MetroLink

Transport Infrastructure Ireland

Groundborne Noise and Vibration Amendments

ML1-JAI-EGN-ROUT_XX-RP-Z-00003| P01.1

- Tunnel
- Station Locations
- Additional FST lengths as a result of New 'Medium' impacts

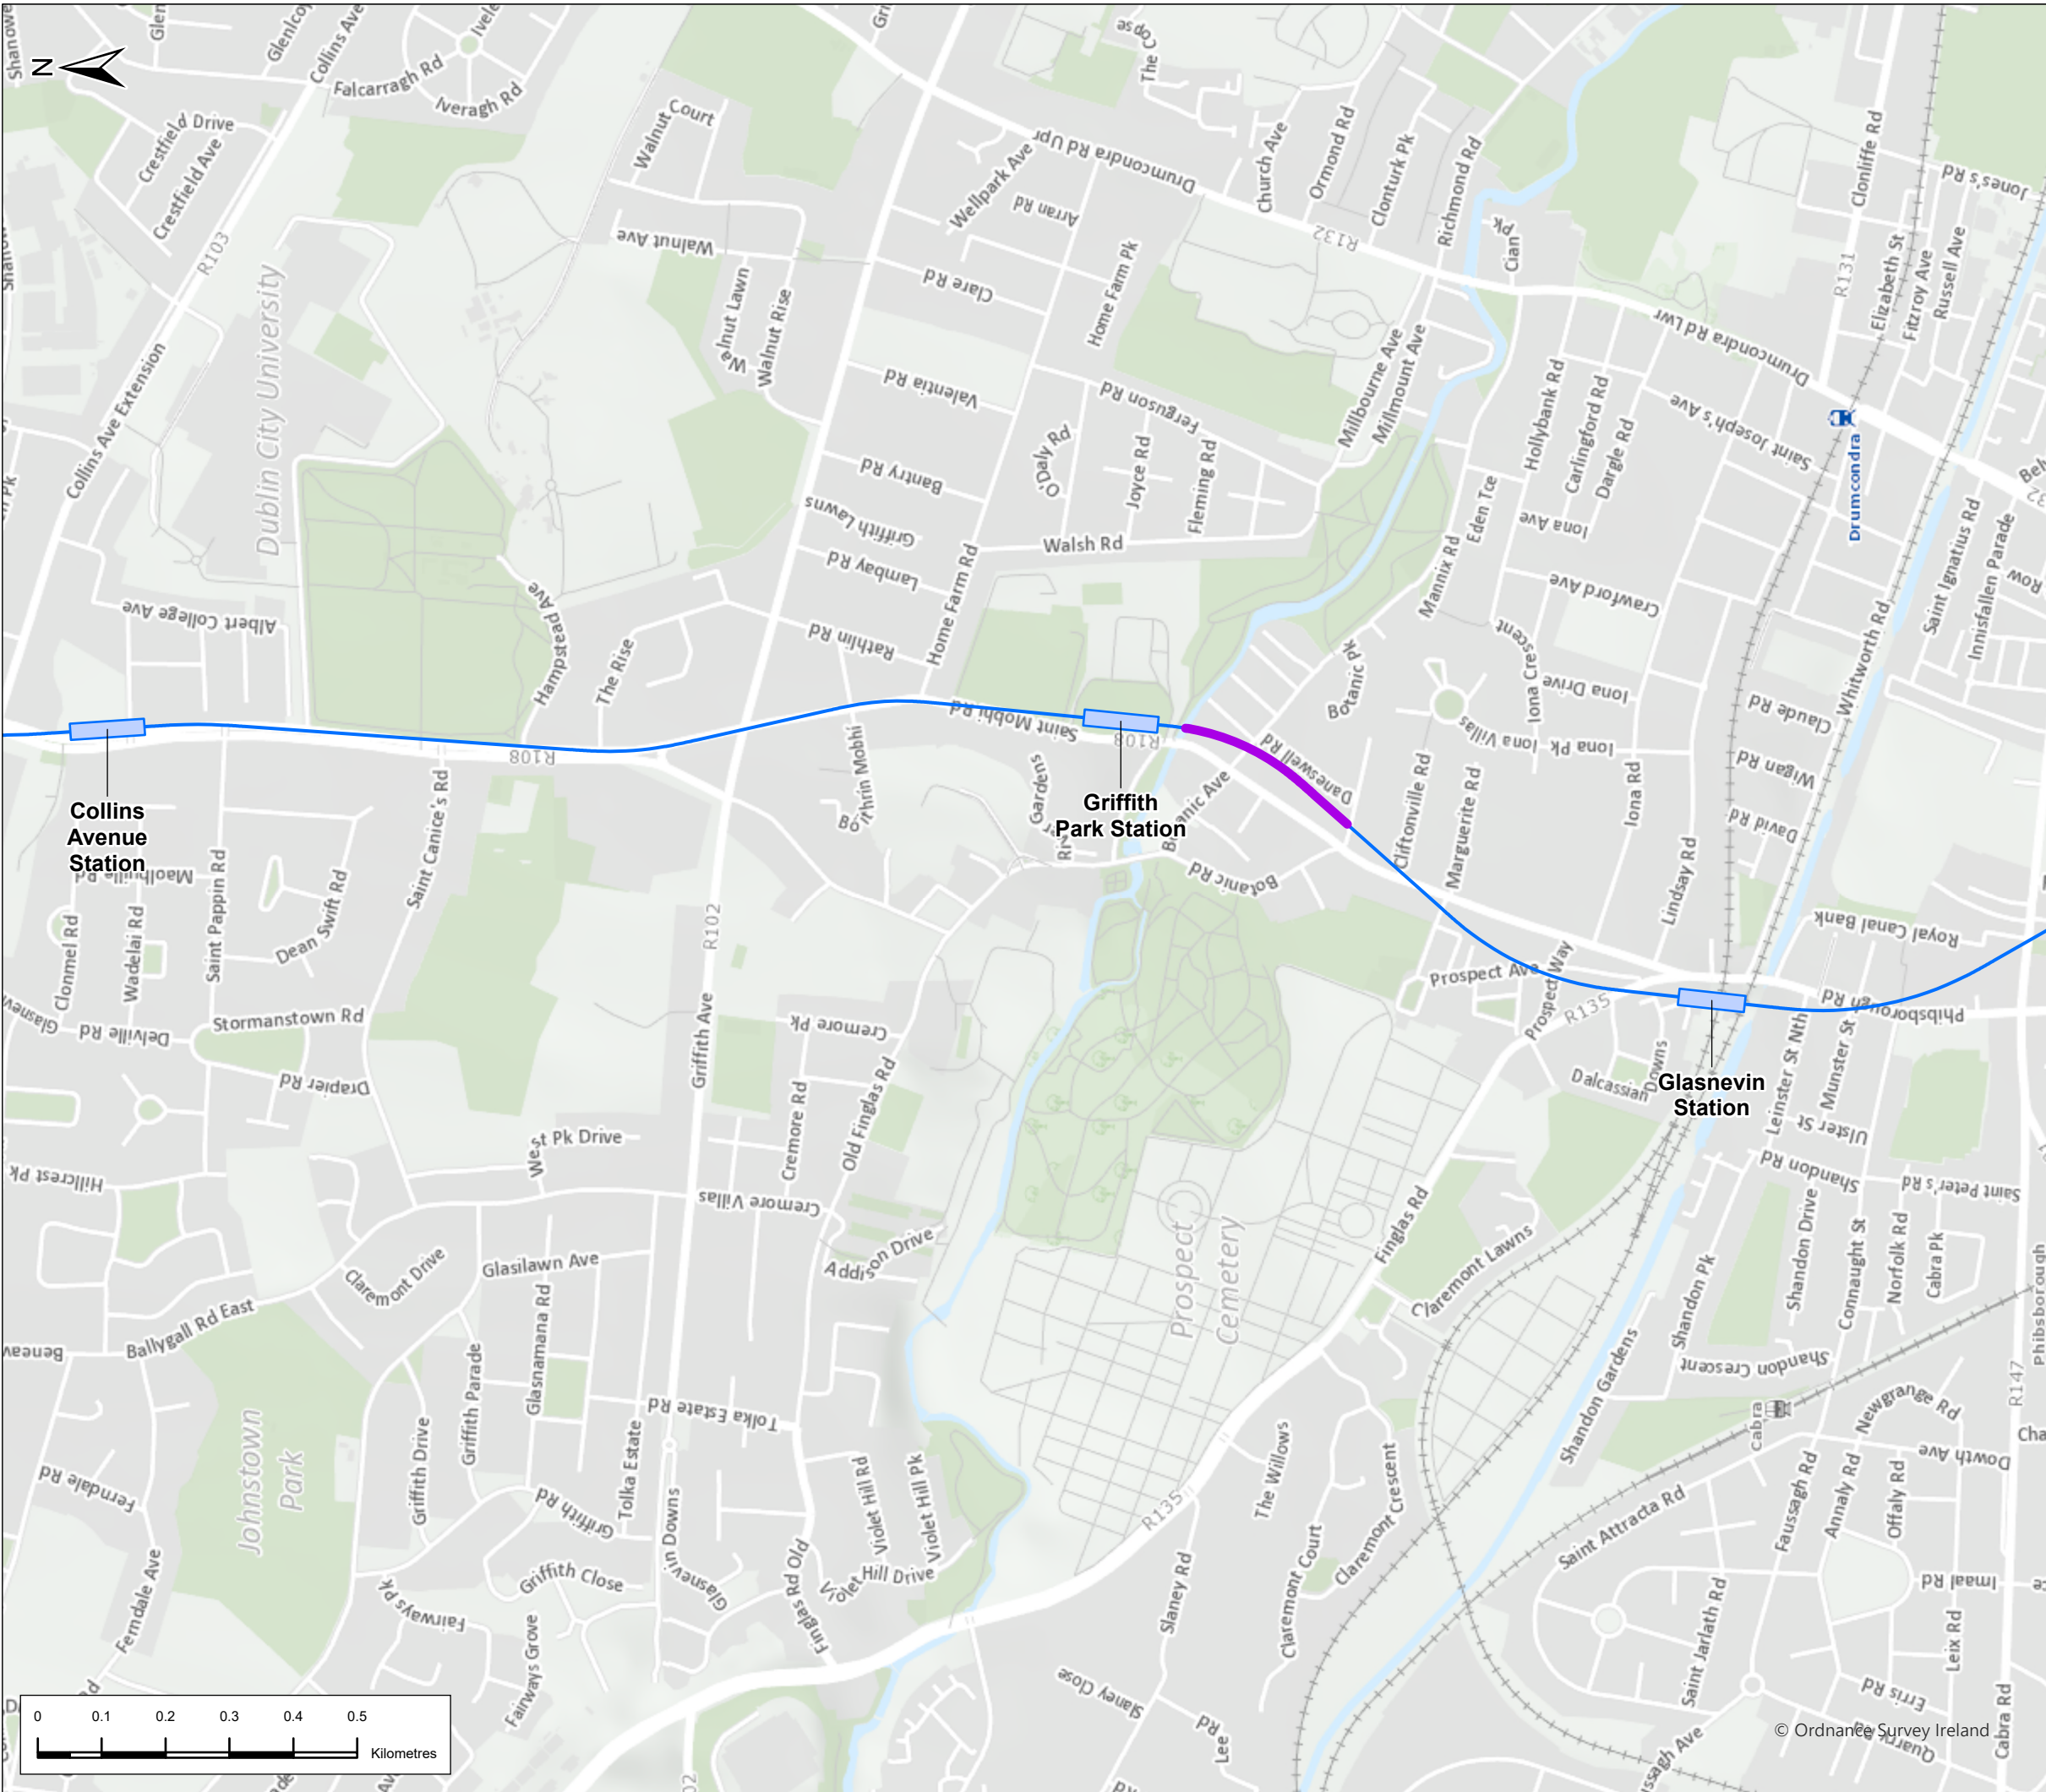
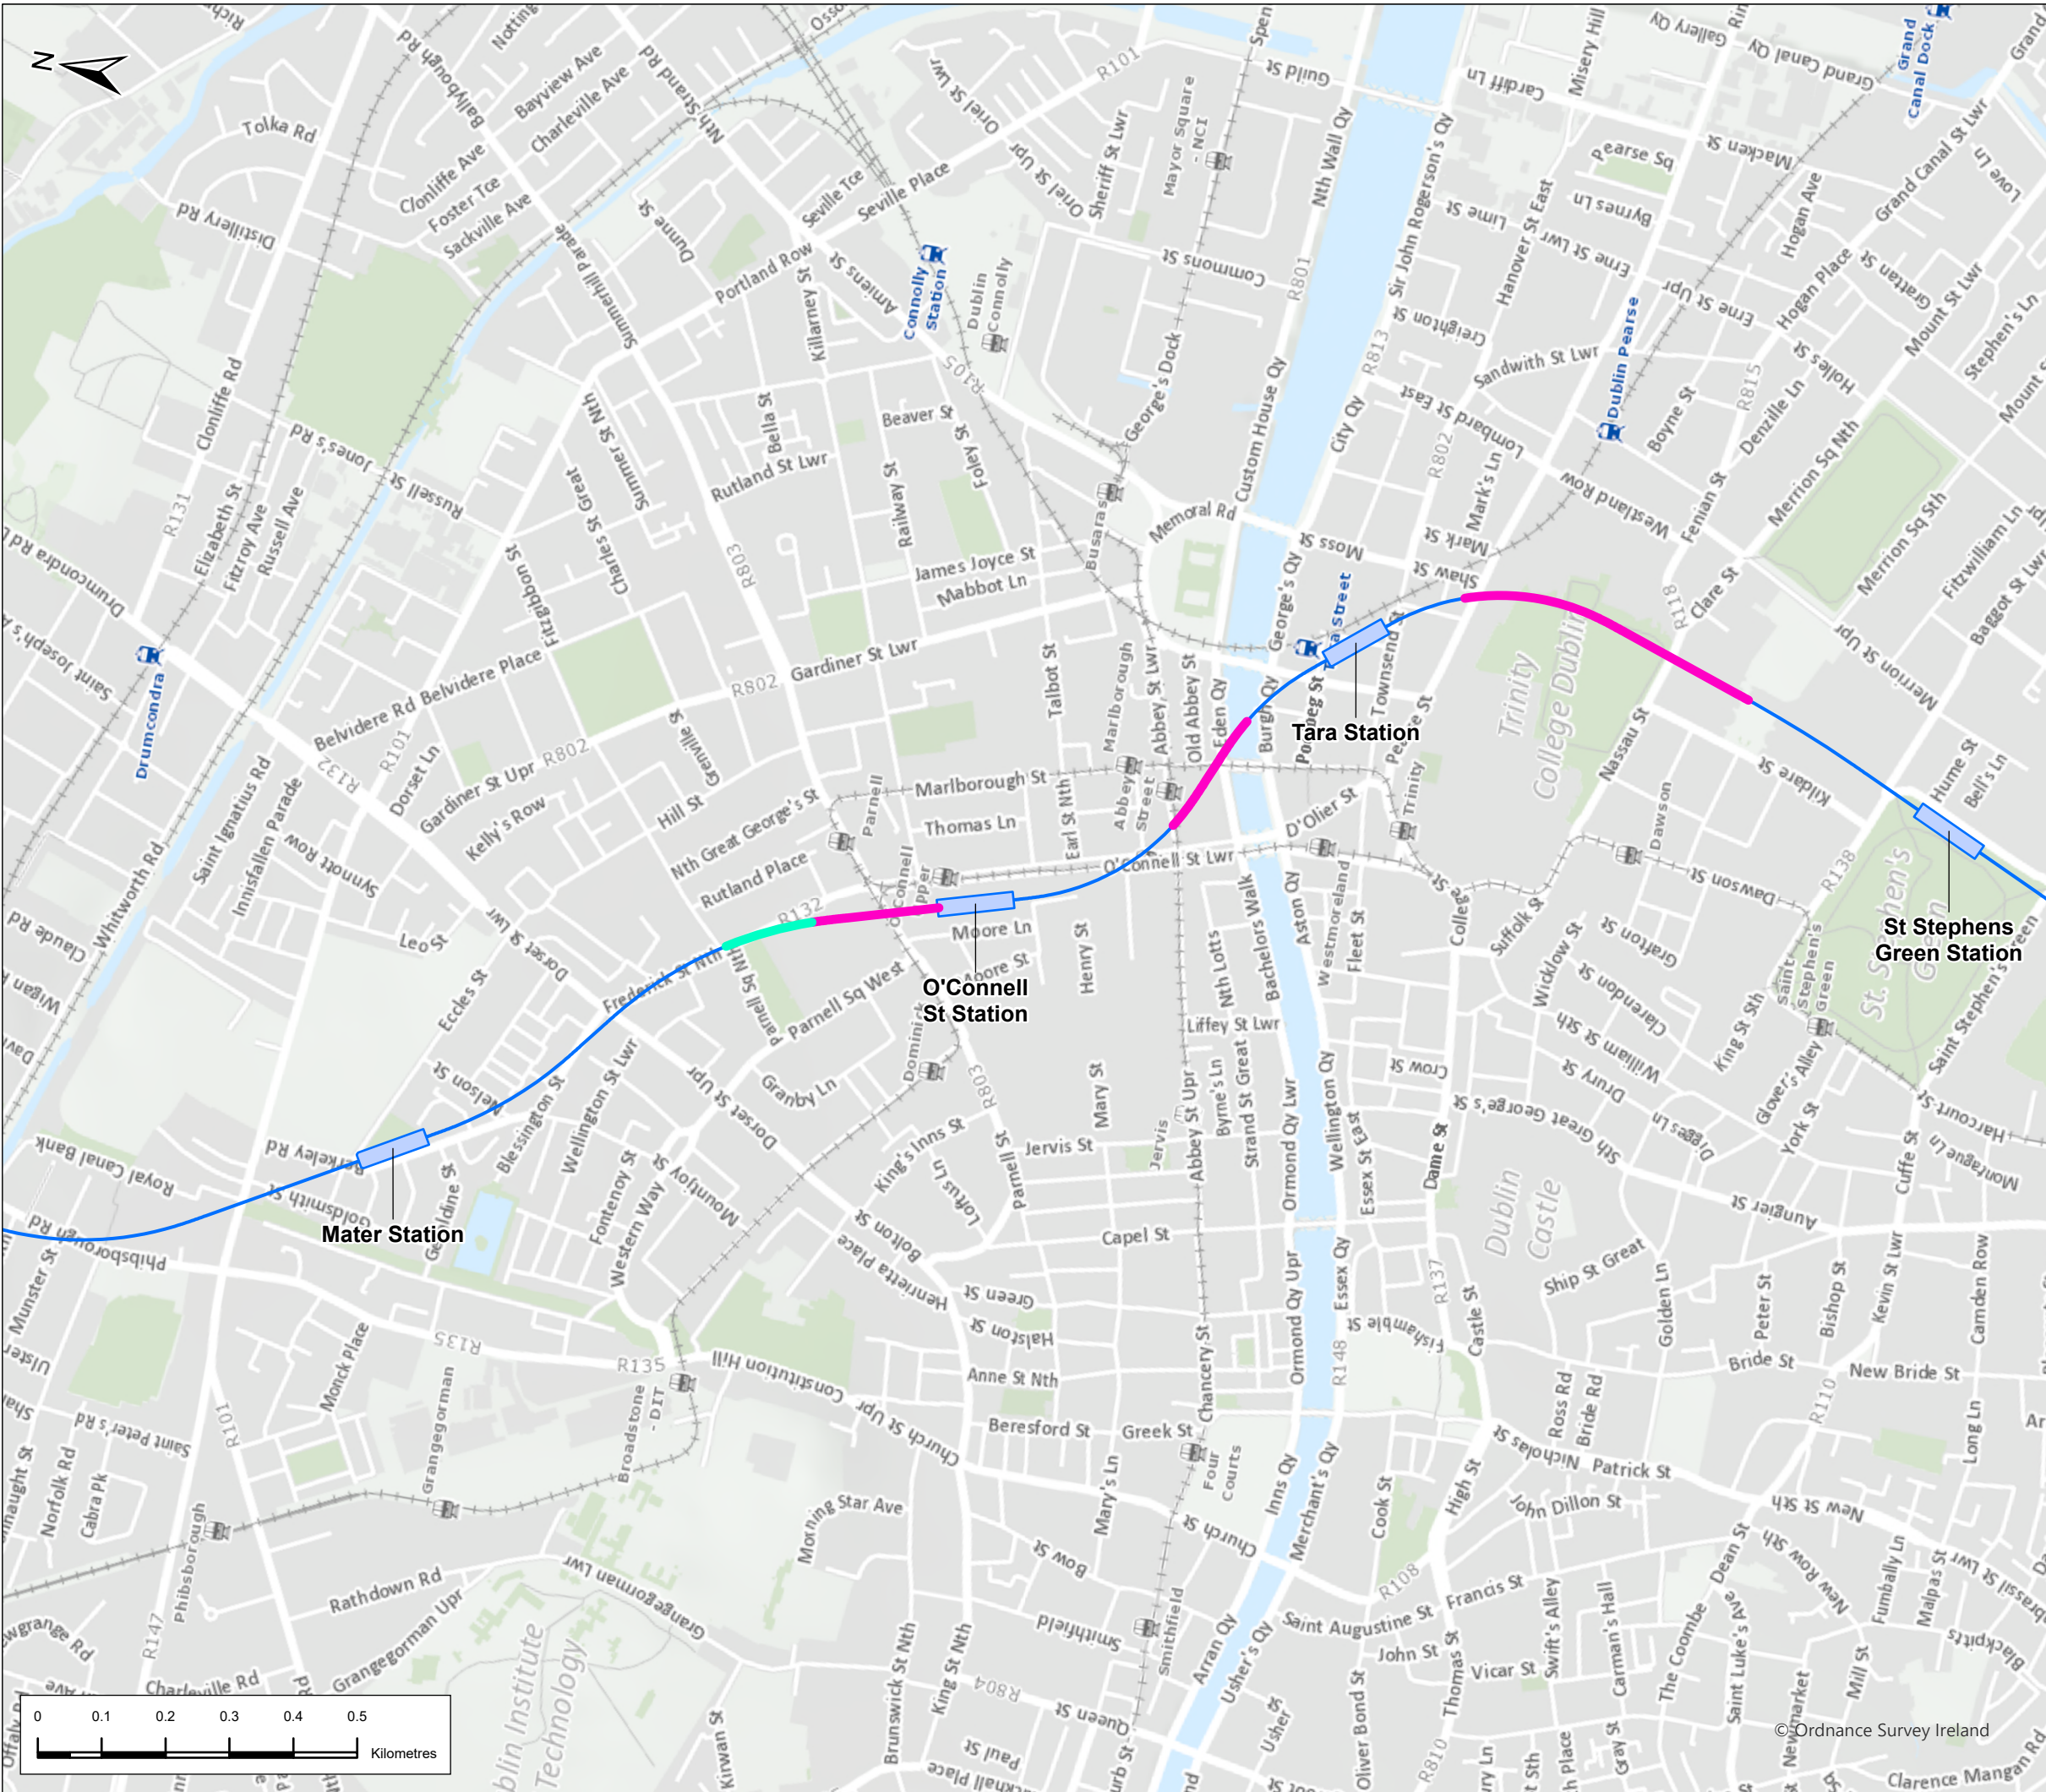
In order to mitigate these exceedances mitigation in the form of enhanced track support measures is required. Enhanced track support locations are listed in EIAR Table 14.47, which is reproduced below and includes the additional measures highlighted over three rows. An additional Figure 14.8 has been produced to demonstrate the location of these proposed FST measures.

Location	Receptor(s)	Design Measure	Threshold to be Met
AZ1, CH. 2+260 to Ch. 2+400	Seaview Mews	Floating Slab Track	40 dB $L_{Amax,S}$

Location	Receptor(s)	Design Measure	Threshold to be Met
AZ1, CH. 2+260 to Ch. 2+400	Veterinary Clinic	Floating Slab Track	40 dB L _{Amax,S}
AZ1, Ch 3,920 to Ch. 4,080	Airside Business Park	Floating Slab Track	40 dB L _{Amax,S}
AZ1, Ch 5,180 to Ch. 5,360	Grove Commercials	Floating Slab Track	45 dB L _{Amax,S}
AZ4, Ch 13,910 to Ch. 14,230	Botanic Avenue & Daneswell Road	Floating Slab Track	40 dB L _{Amax,S}
AZ4, Ch 16+400 to Ch. 16+600	Gate Theatre	Floating Slab Track	25 dB L _{Amax,S} VC-E
AZ4, Ch 17+000 to Ch. 17+200	Abbey Theatre	Floating Slab Track	25 dB L _{Amax,S} VC-E
AZ4, Ch 17+600 to Ch. 17+980	Trinity College Buildings	Floating Slab Track	VC-E
AZ4, Ch 17+980 to Ch. 18+100	National Museums & National Gallery	Floating Slab Track	VC-E
AZ4, Ch 18+760 to Ch. 18+940	National Concert Hall	Floating Slab Track	25 dB L _{Amax,S} VC-E
